# The Planning Inspectorate

Our Ref: EN020021

### **Application by SP Manweb for an Order Granting Development Consent for the Reinforcement to the North Shropshire Electricity Distribution Network**

#### **Advice following issue of decision to accept the application for Examination**

Title:
Reinforcement to North Shropshire Electricity
Distribution Network
Order 201X
Works Plan Key Plan (Sheet 0 of 16)
Document 2.3.0
Regulation 5(2)(j)

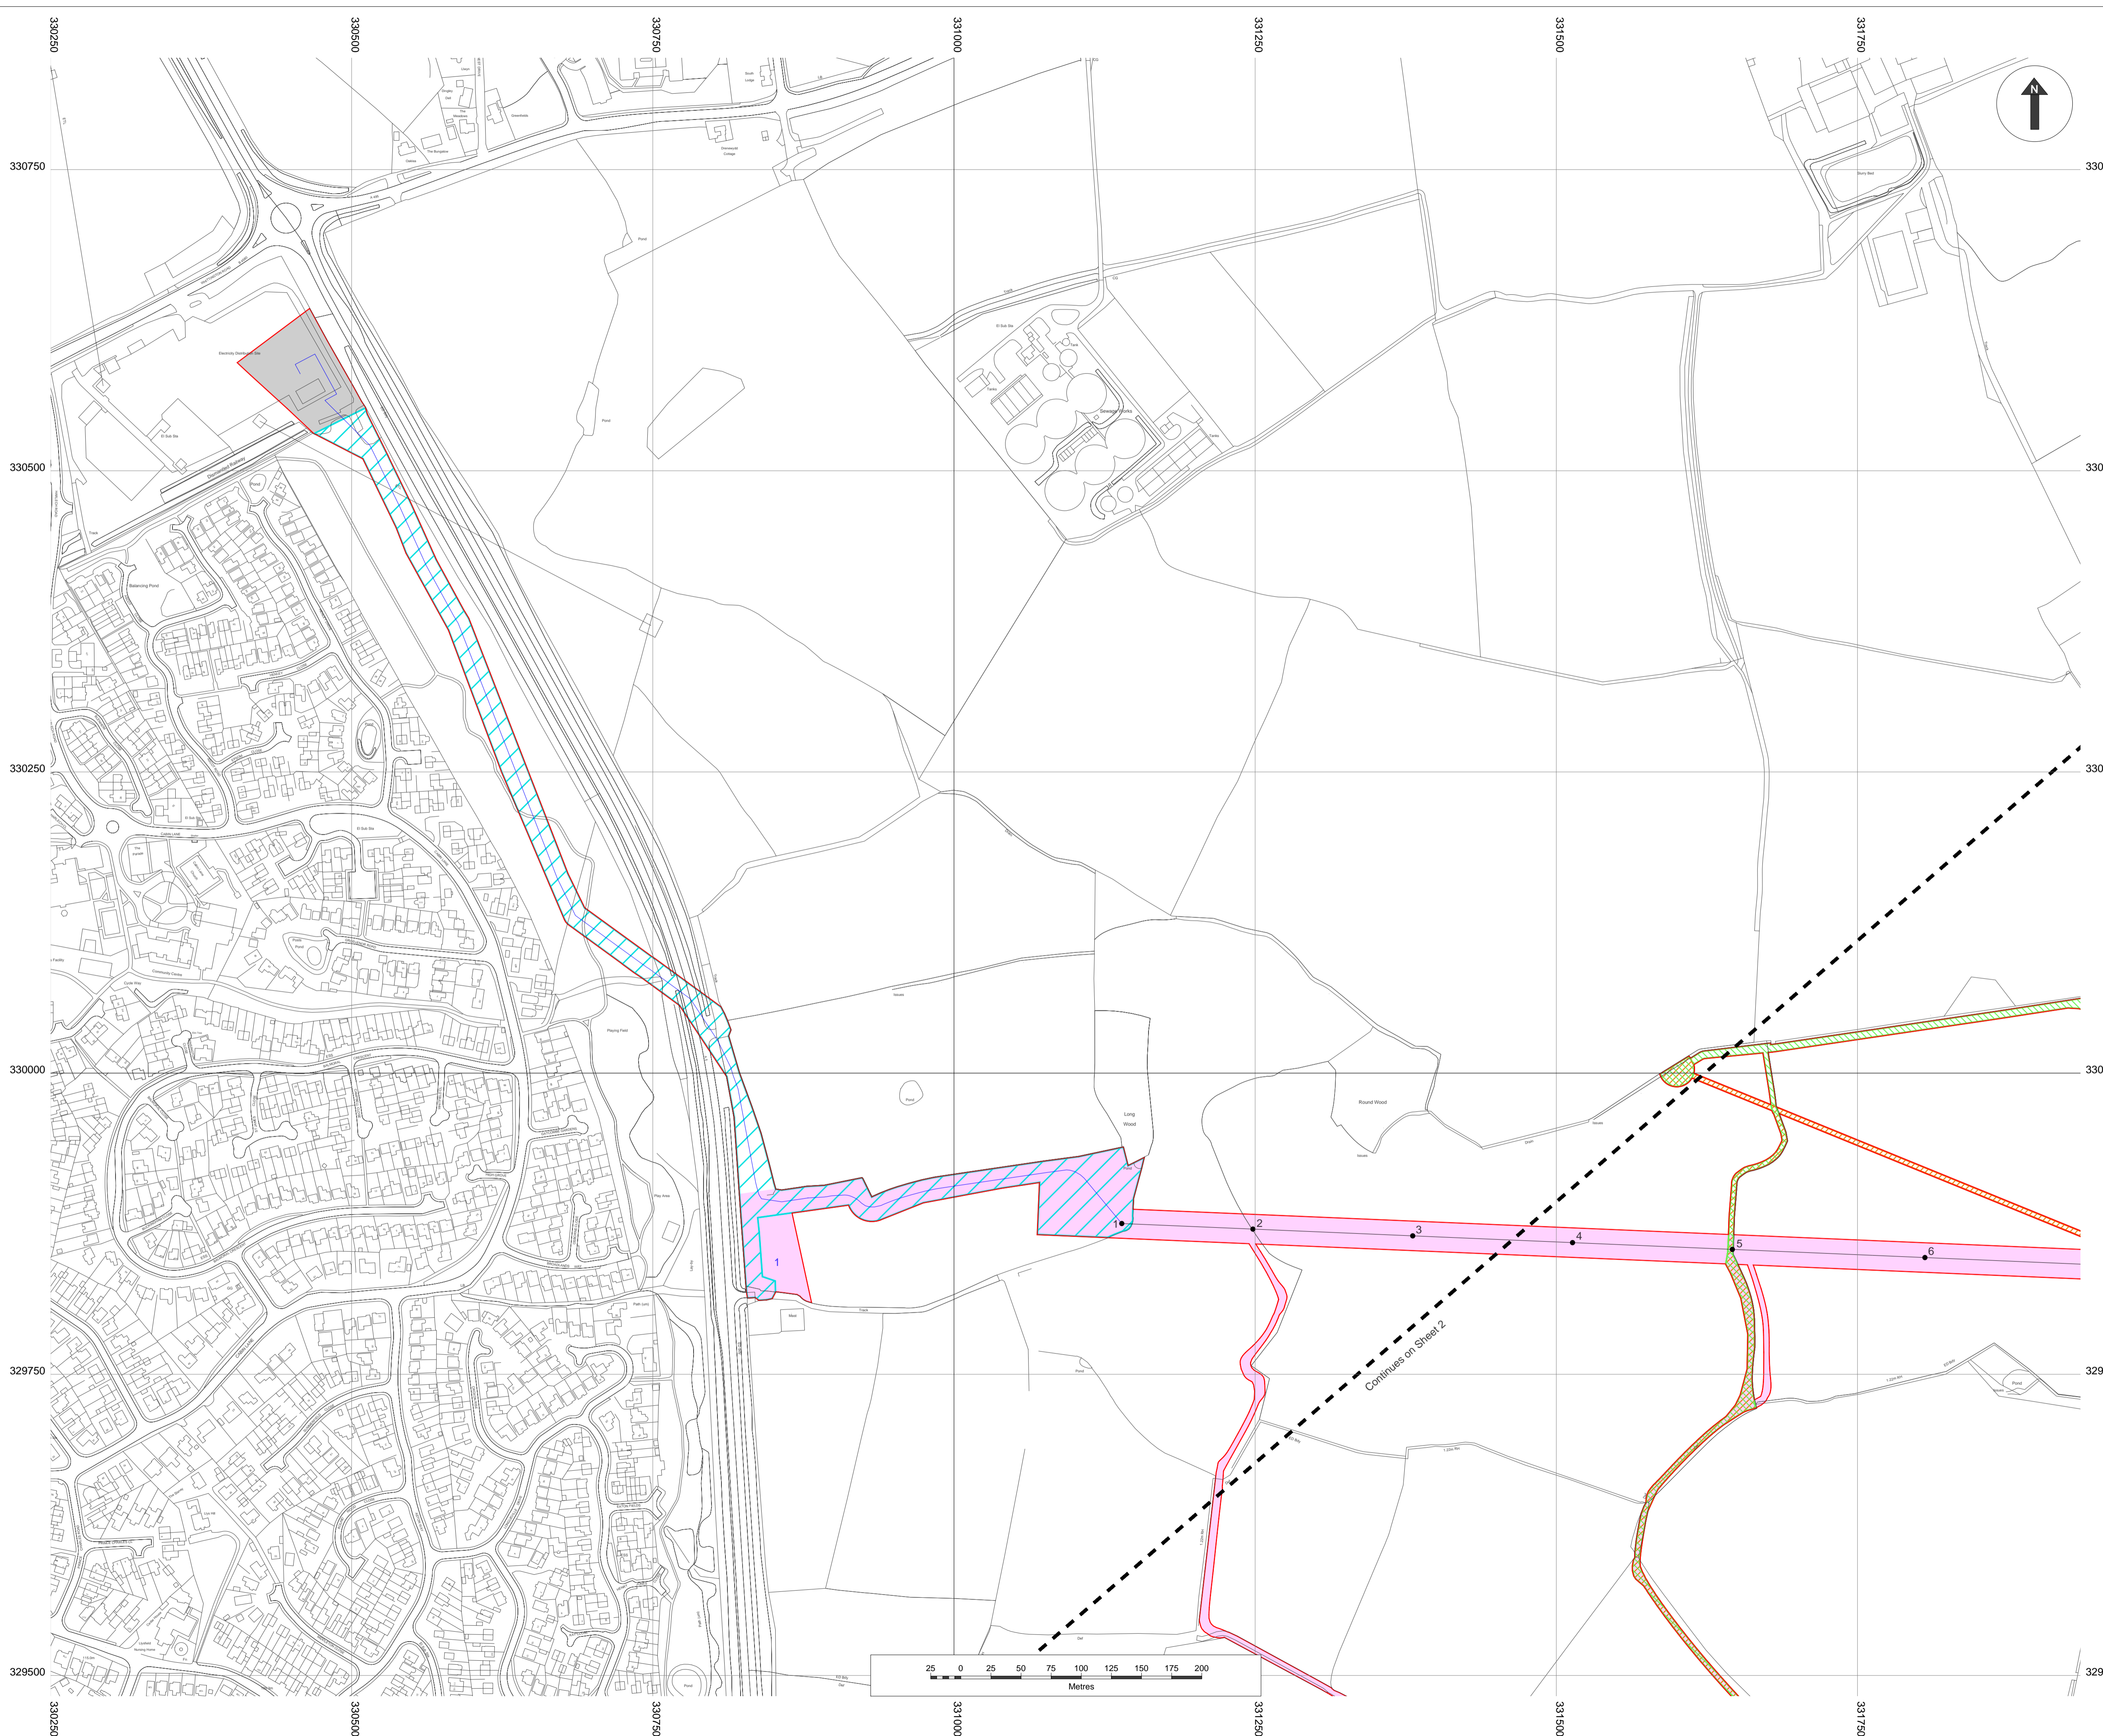
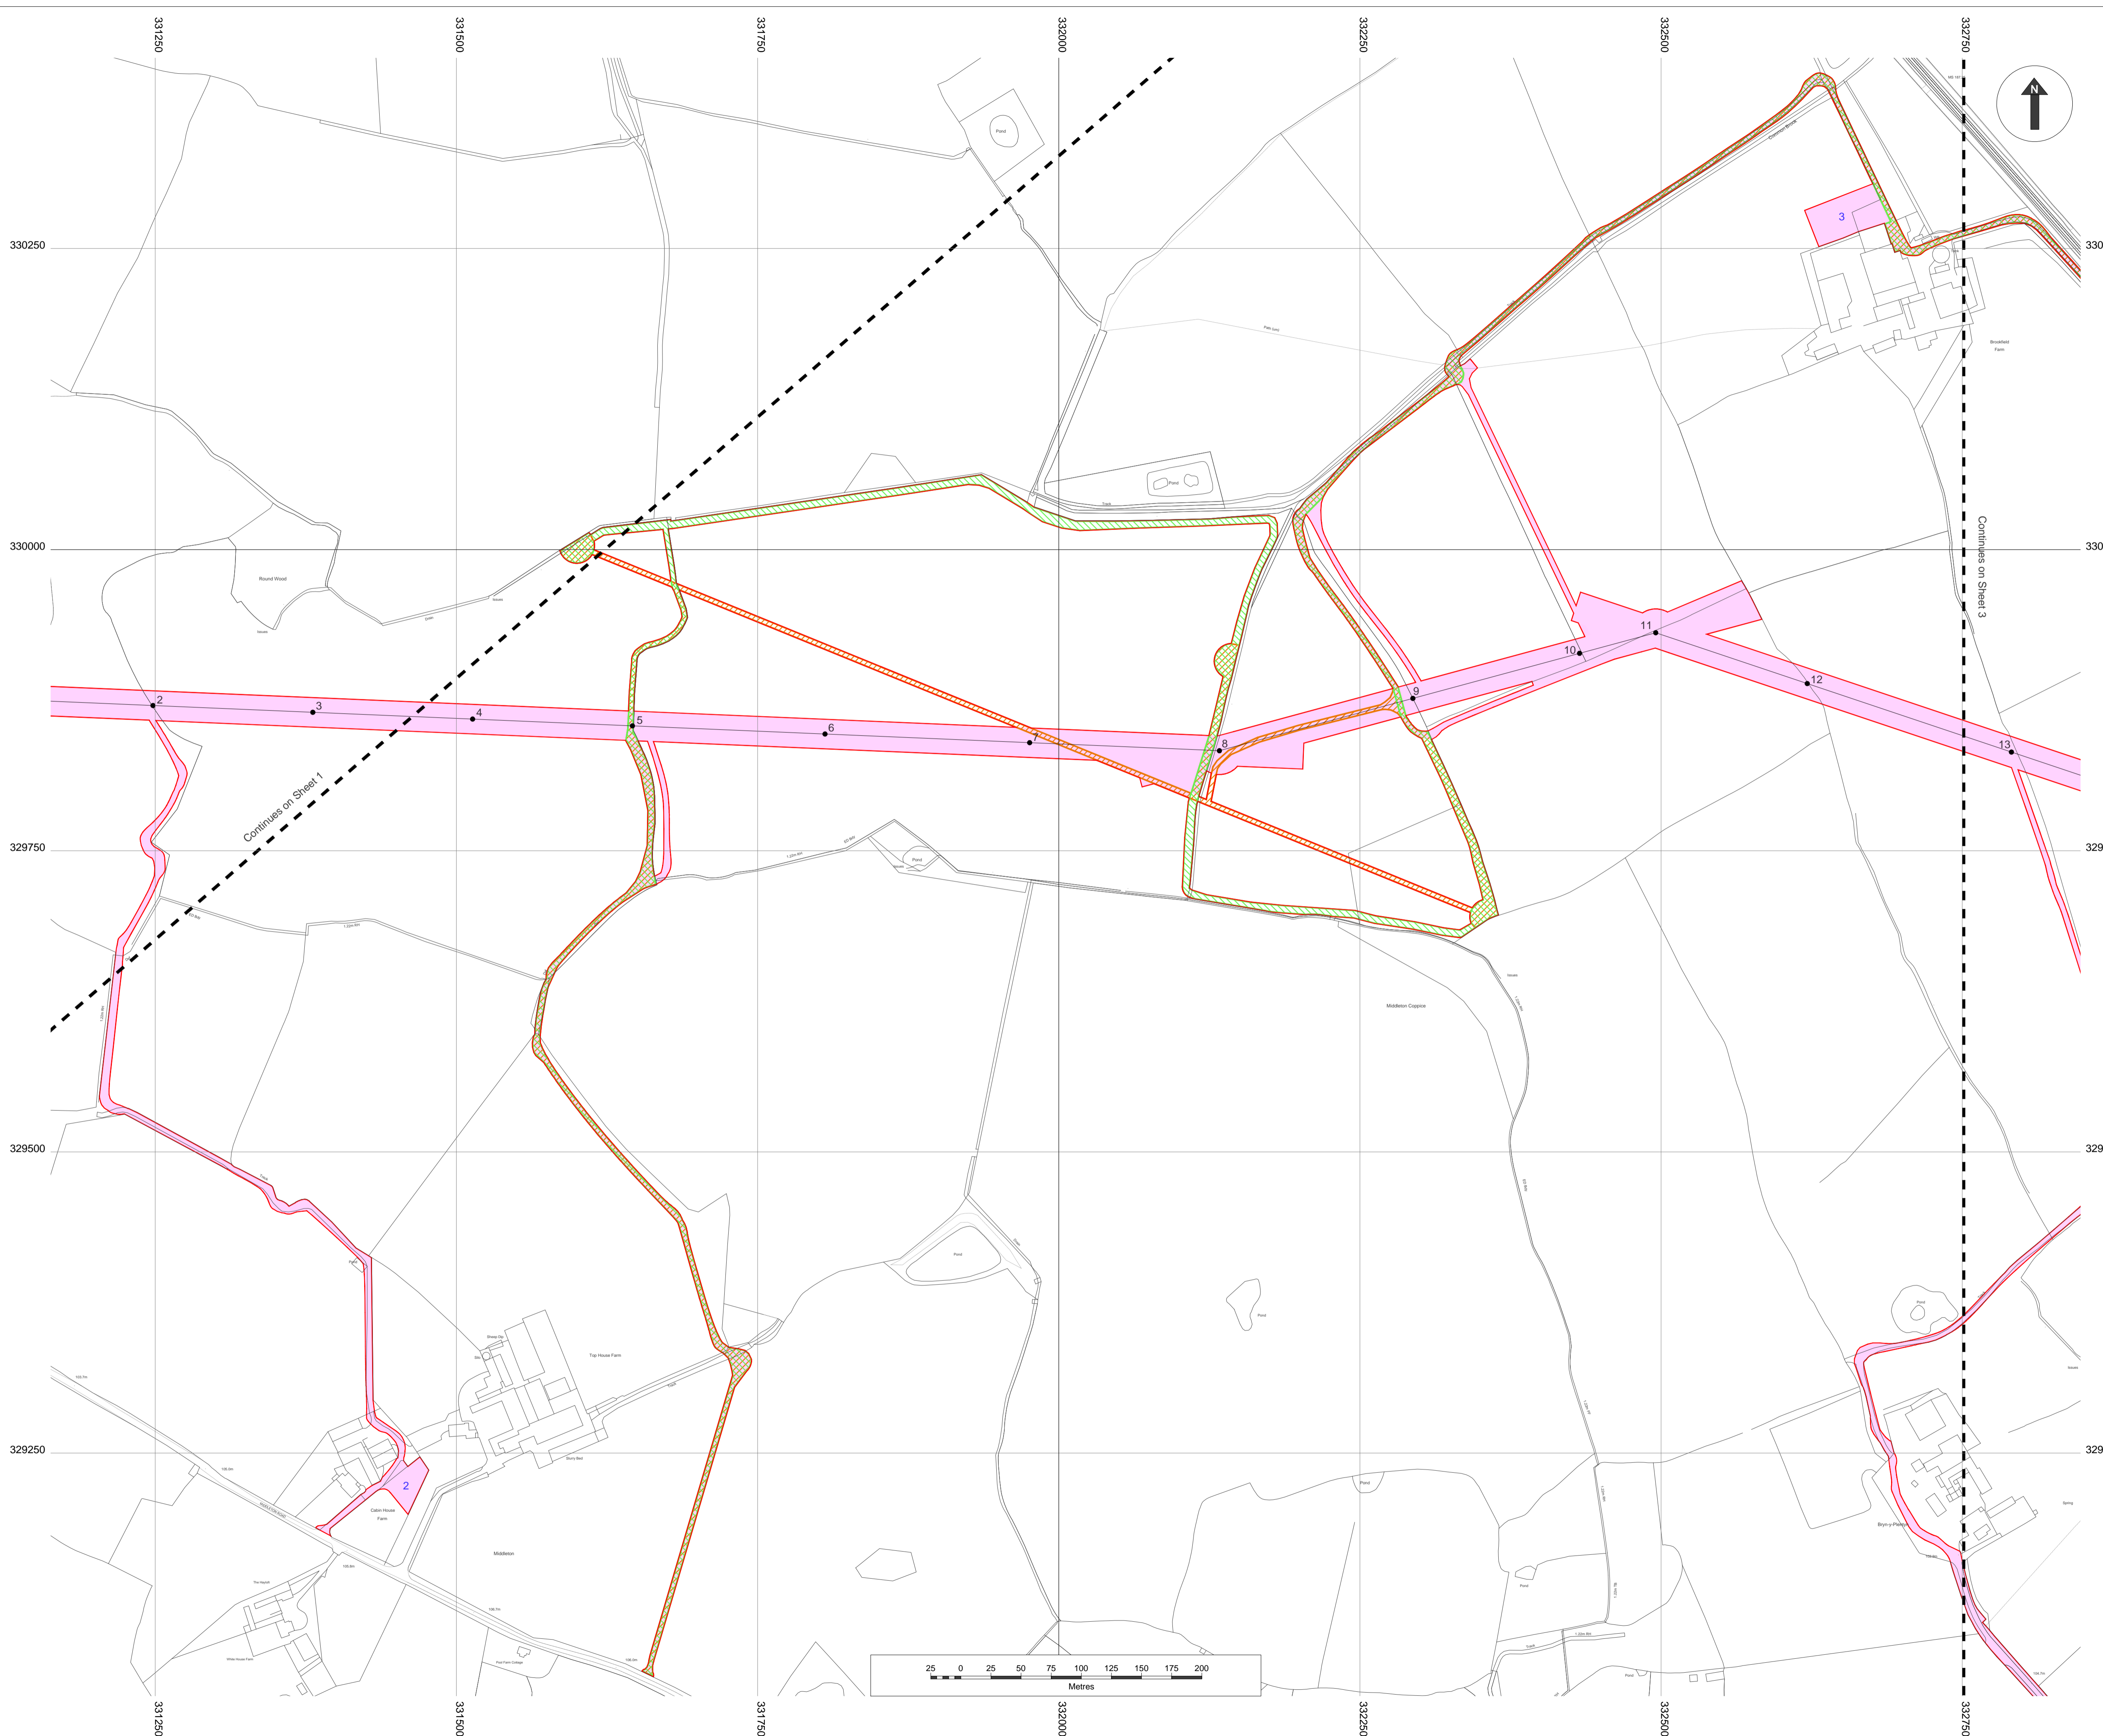
It is noted in the Checklist that the lateral limits of deviation for the poles are not shown on the Works Plans. The Applicant is advised to provide a clear explanation of the relationship between article 4(1)(a), Requirements 3 and 4 of the draft DCO, and the Works Plans, and show the limits of deviation for Work No.3 on revised Works Plans.
